**Heyford Park, Camp Road, Upper Heyford,  
Bicester, OX25 5HD**

**23/01959/NMA**

**Proposal:** Non-material amendment to 16/02446/F - amended elevation plans for 7 plots (plots 630-632, 634-635 & 646-647)

REAR ELEVATION

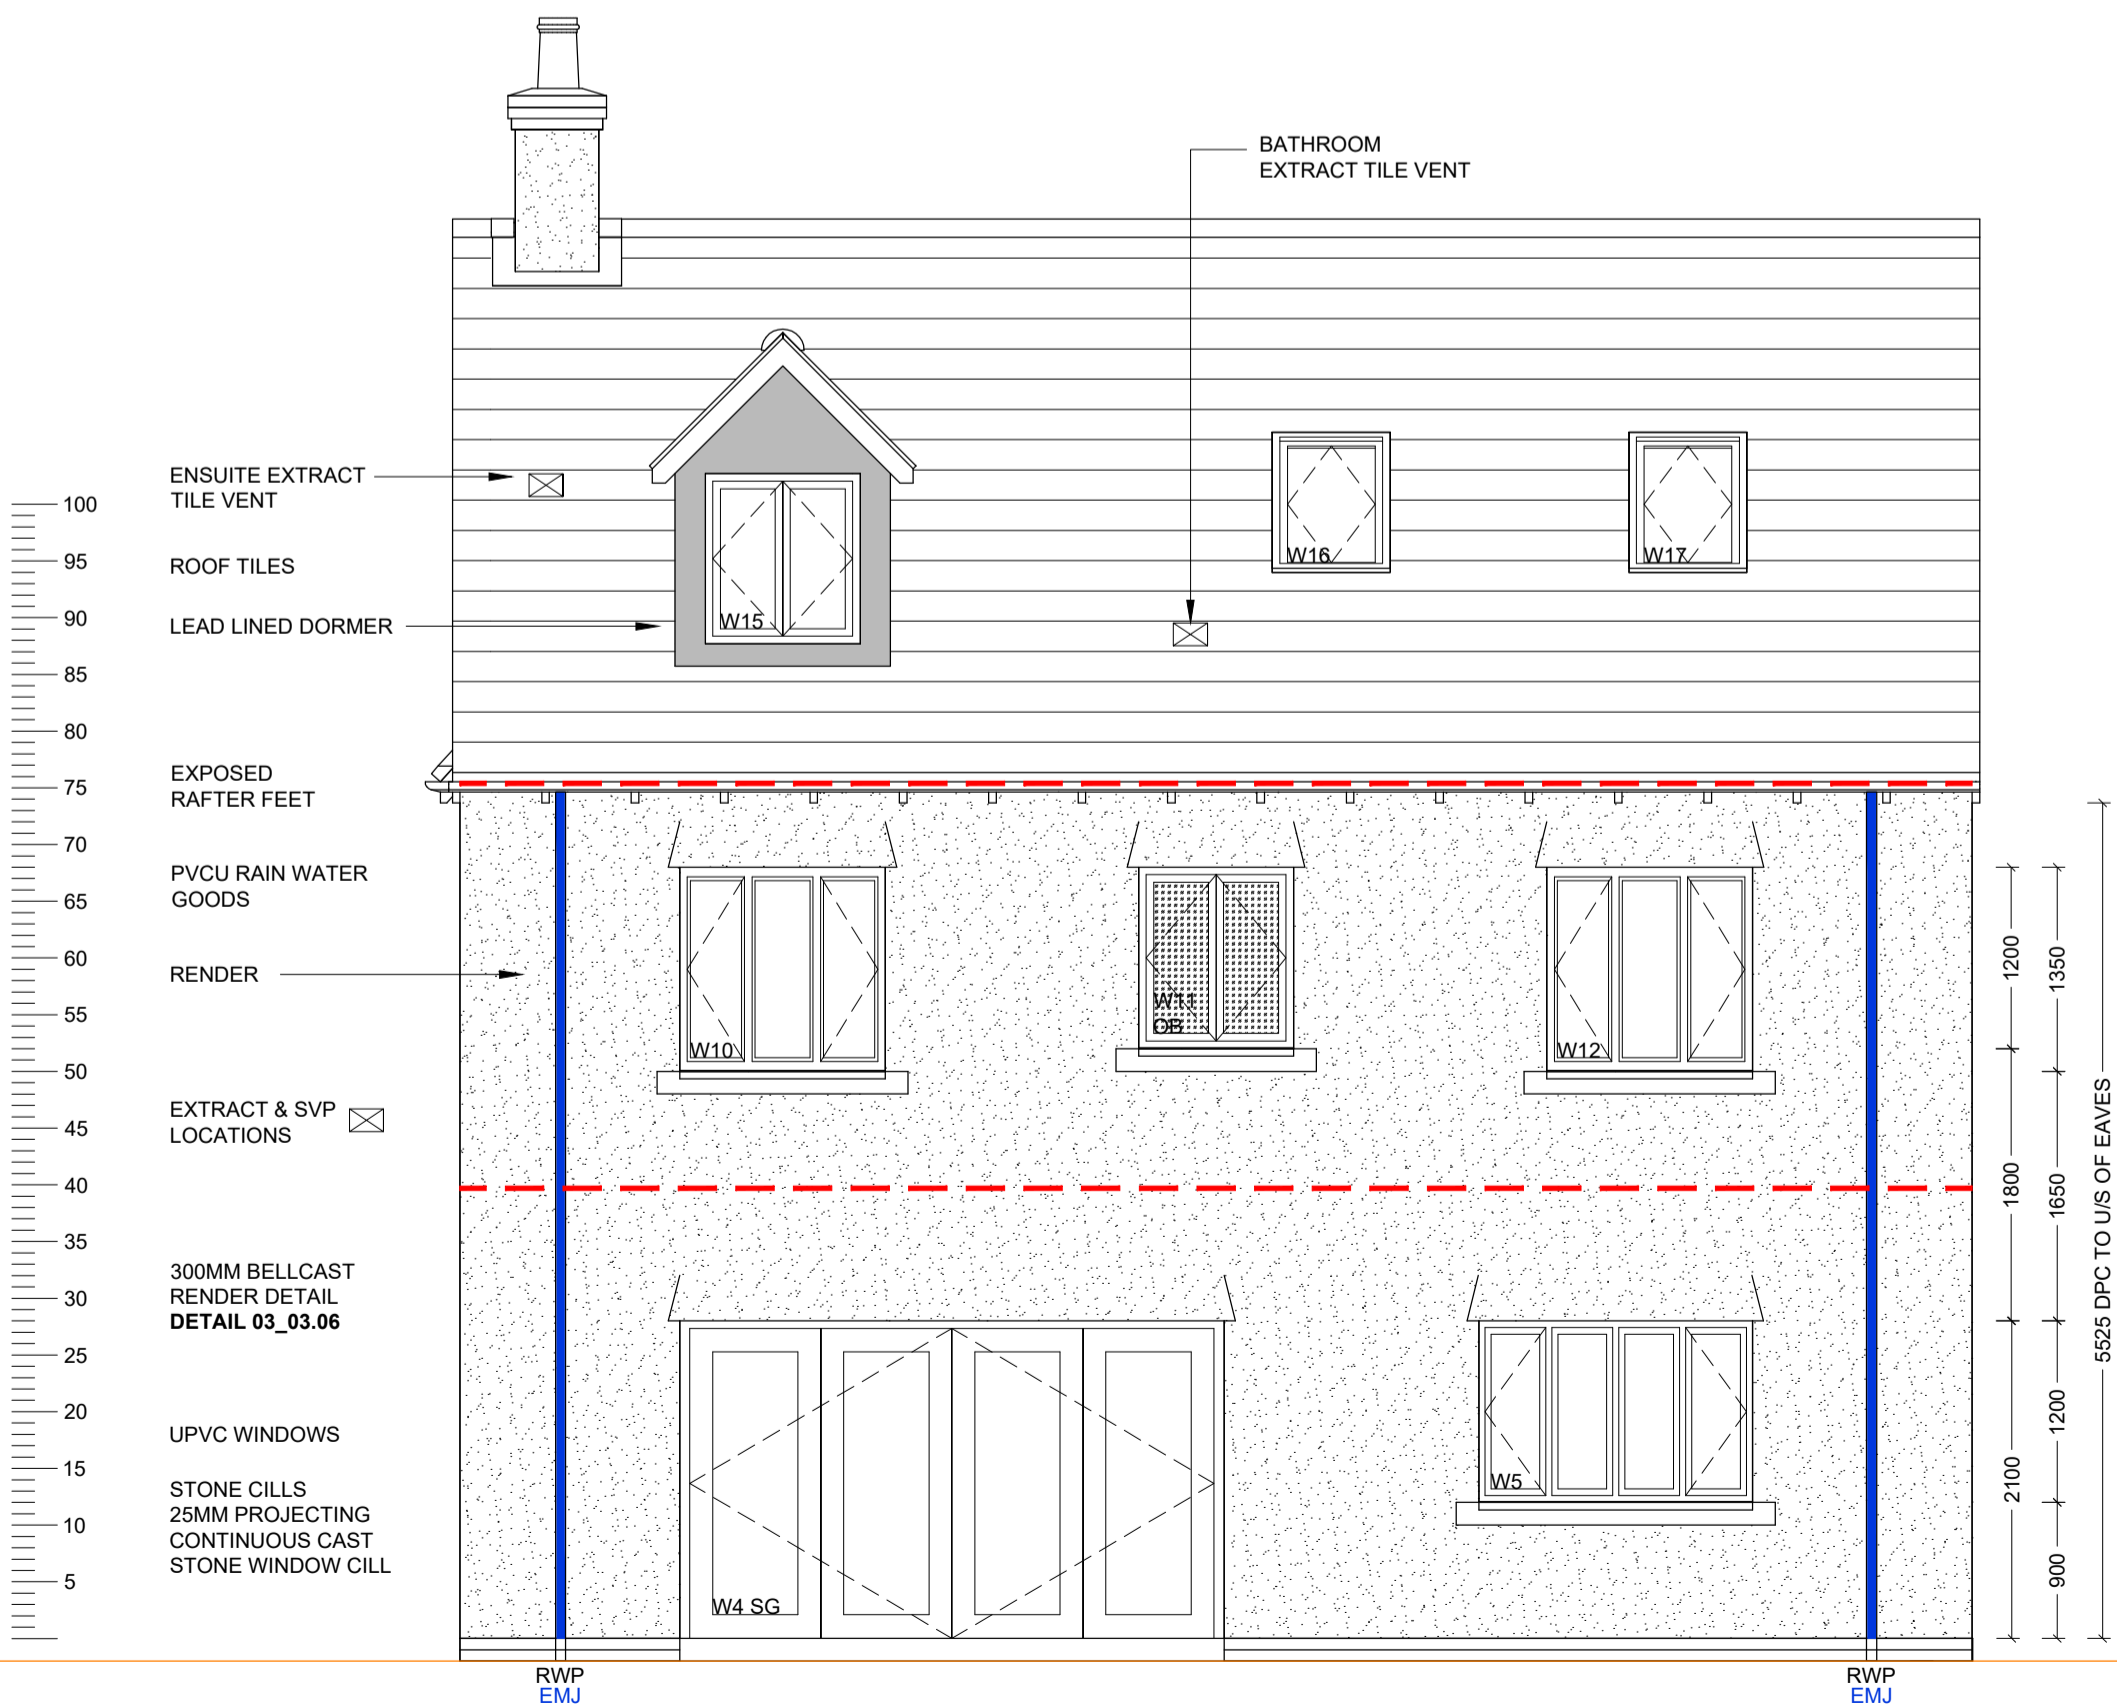
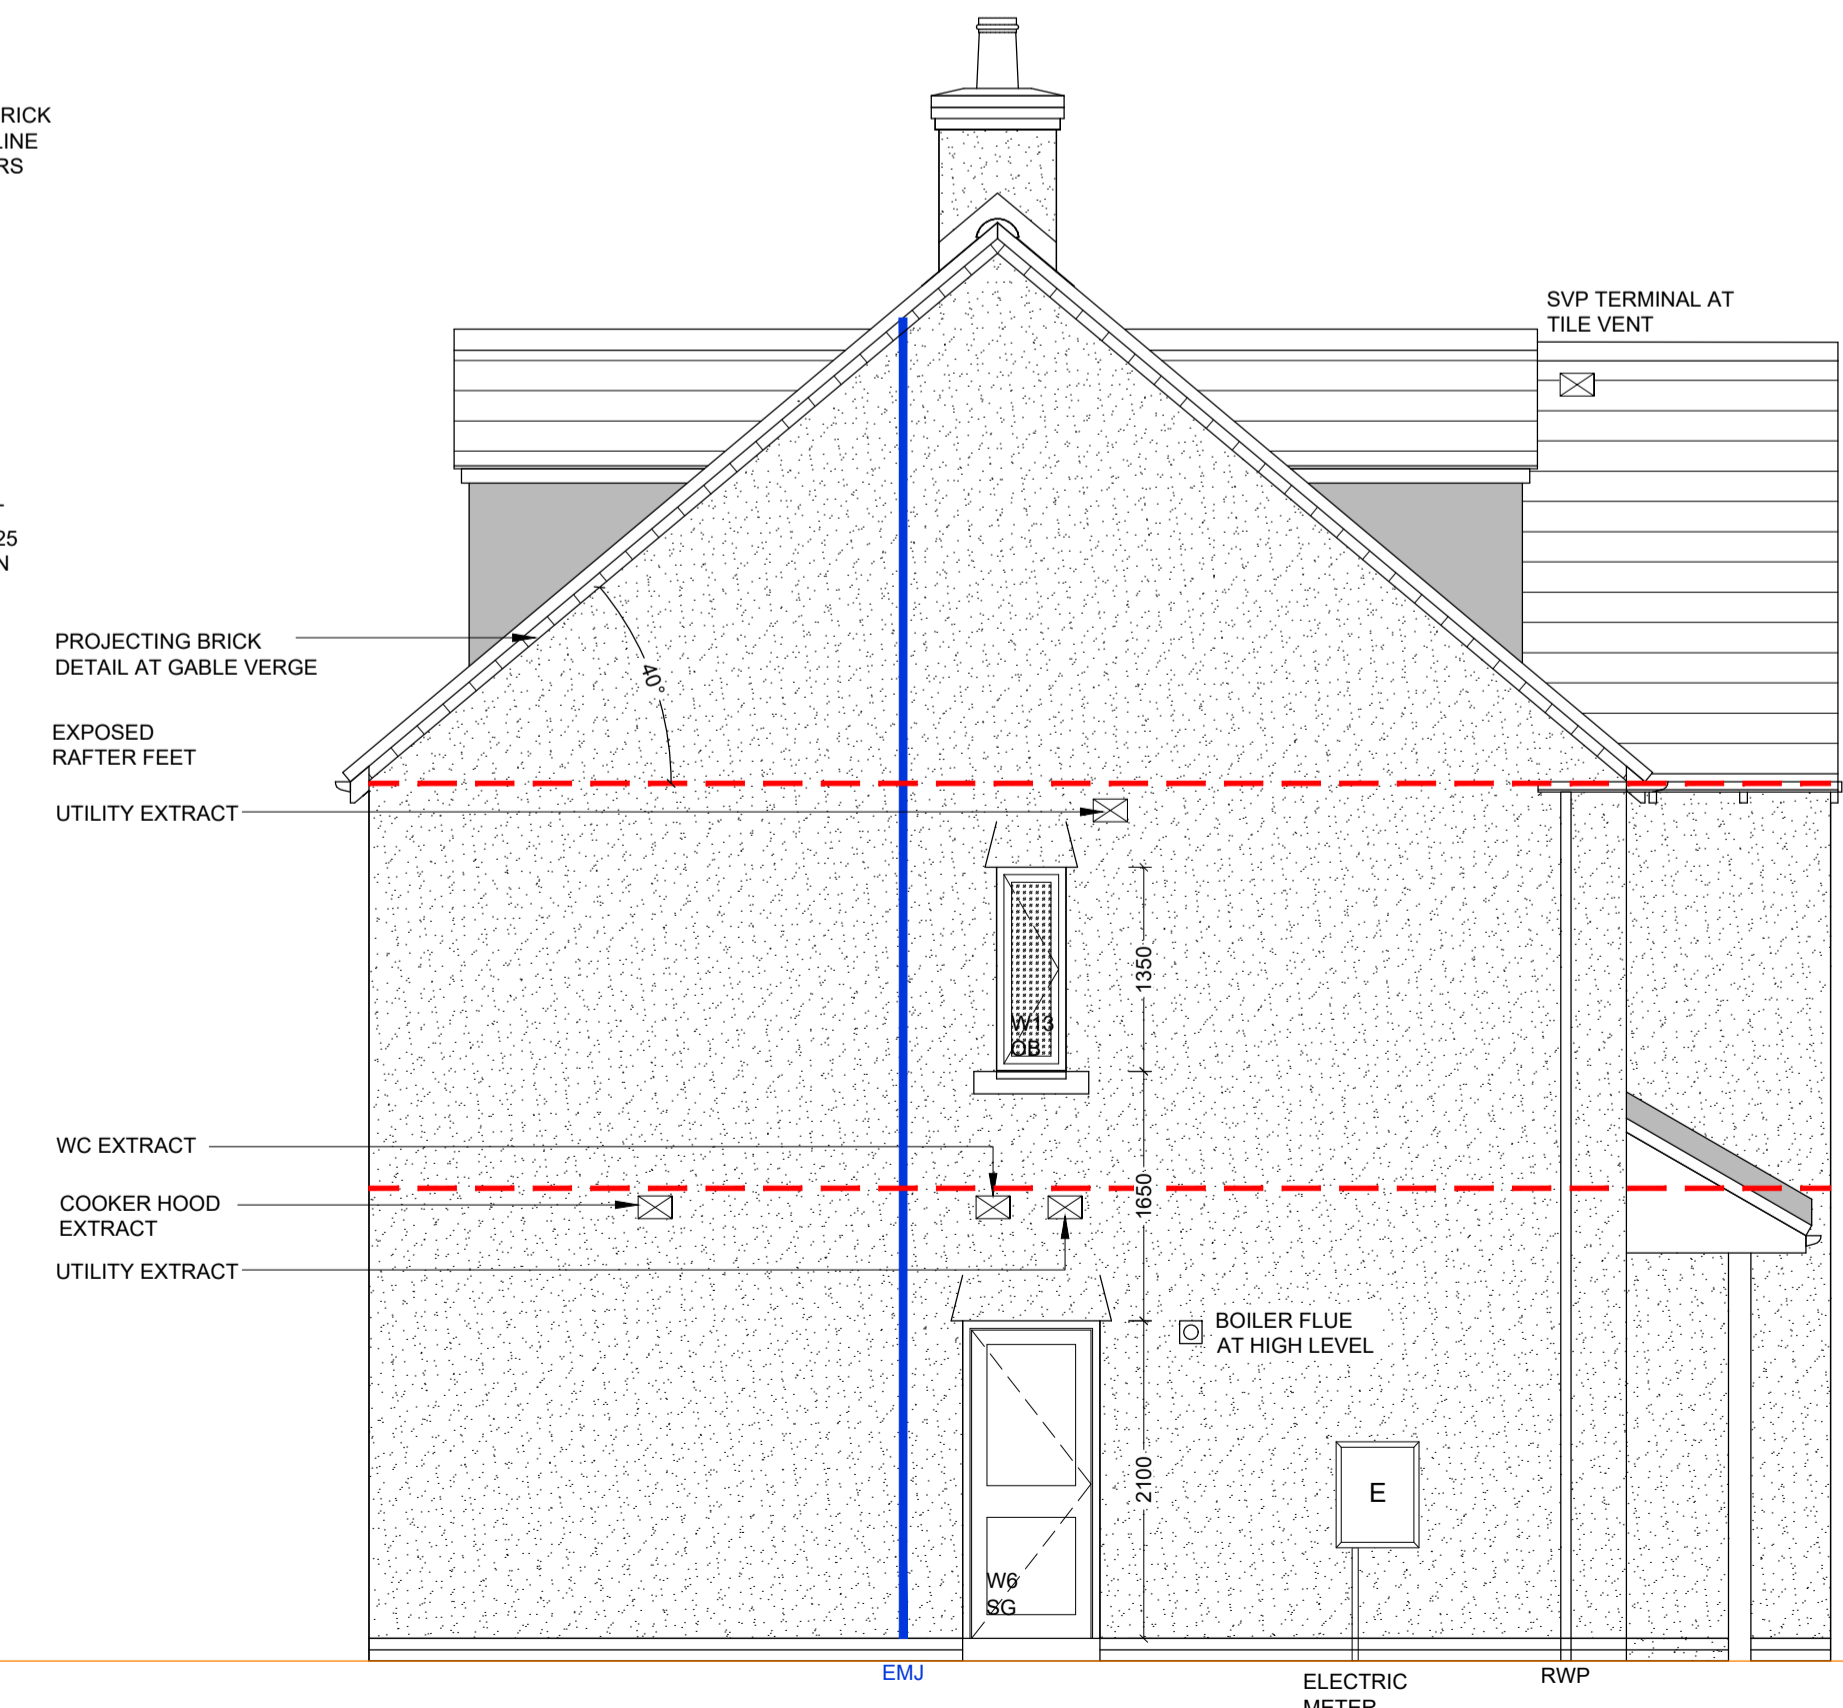
#### House Type 4A – Plot no.632

- Both render and brick elevations have stone surrounds added;
- Brick elevations have quoin detail added to front elevation corners;
- Render elevations have additional brick detailing to gable ends;
- 1st floor windows elongated.
